PROPOSED MODIFICATION TO OAKDALE CENTRAL (LOTS 1C, 28 & 3) WAREHOUSE AND
DISTRIBUTION CENTRES (SSD 6078 MOD 2) EXHIBITION OF ENVIRONMENTAL
ASSESSMENT

Stakeholder Response to Oakdale Unit 2B Notification process

Figure 2 - Approved DG Store layout

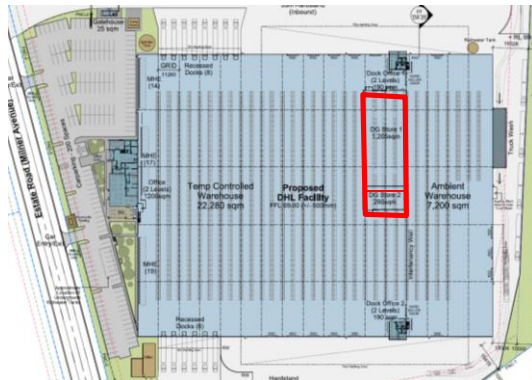
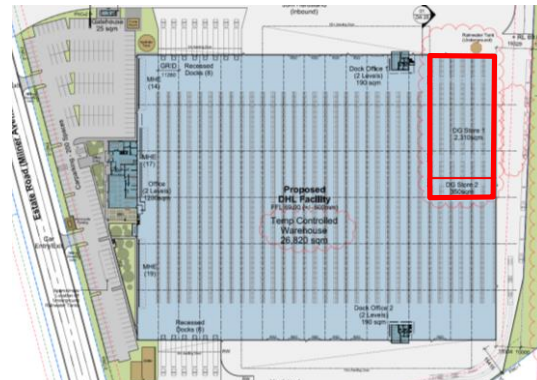
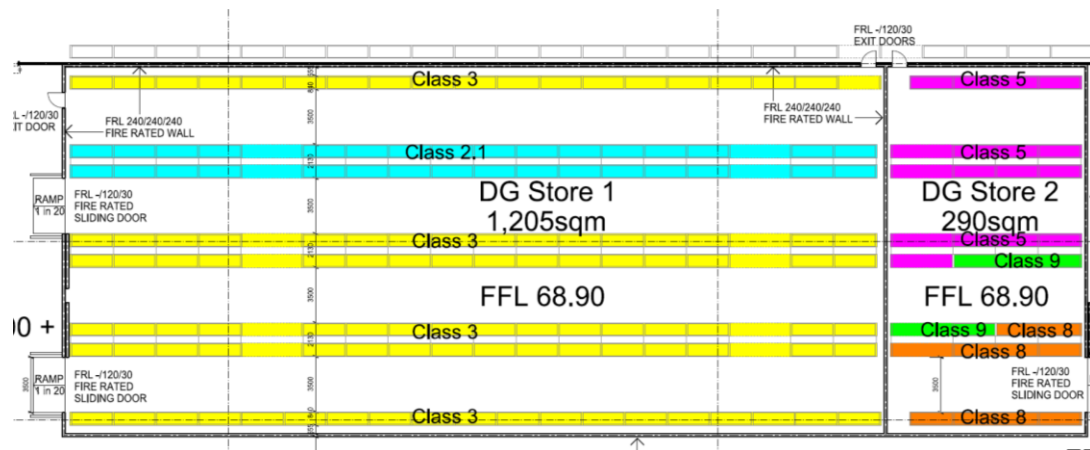
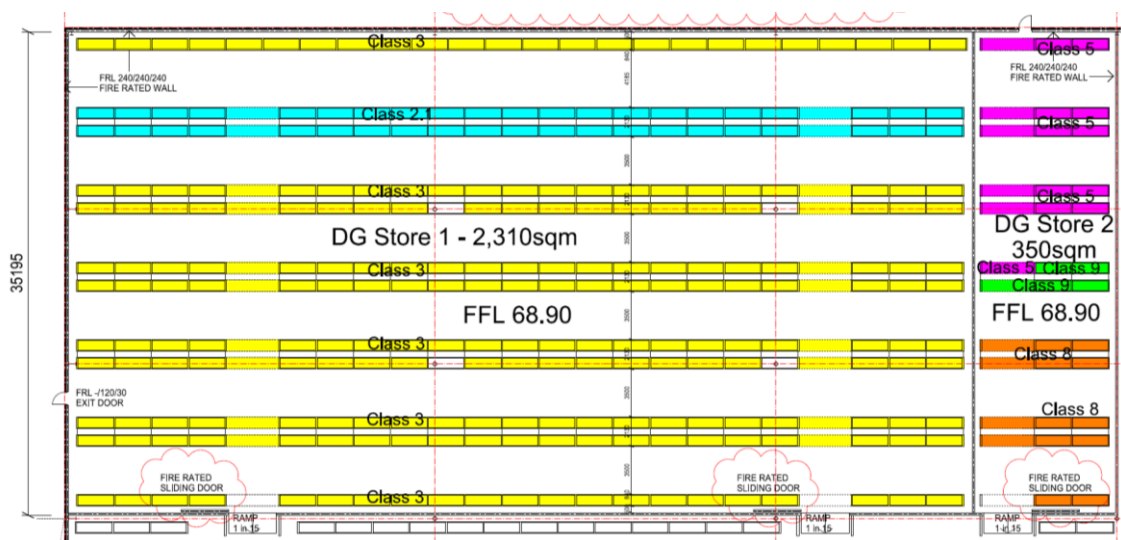
The DG Store must be designed and constructed in accordance with relevant Australian Standards. In addition, if OPE approves the proposed modification, the EPA notes the recommendations outlined in the Preliminary Hazard Analysis prepared by RAW Risk Engineering Pty Ltd which state: - Multiple spill kits should be provided around the DG store to ensure spills can be cleaned up immediately following identification; - The fire pumps should be started at least once per month and the system operated at full pump pressure during this monthly test; and - The site emergency plan should include response to spills and spill clean-up procedures. It is also highlighted that "general chemical storage" is a scheduled activity under the Protection of the Environment Operations Act 1997 (POEO Act). If the capacity of the dangerous goods store exceeds the chemical storage thresholds outlined in schedule 1 the POEO Act, an application for an environment protection licence must be submitted to the EPA.	Noted. Goodman agrees with these proposed conditions of consent.
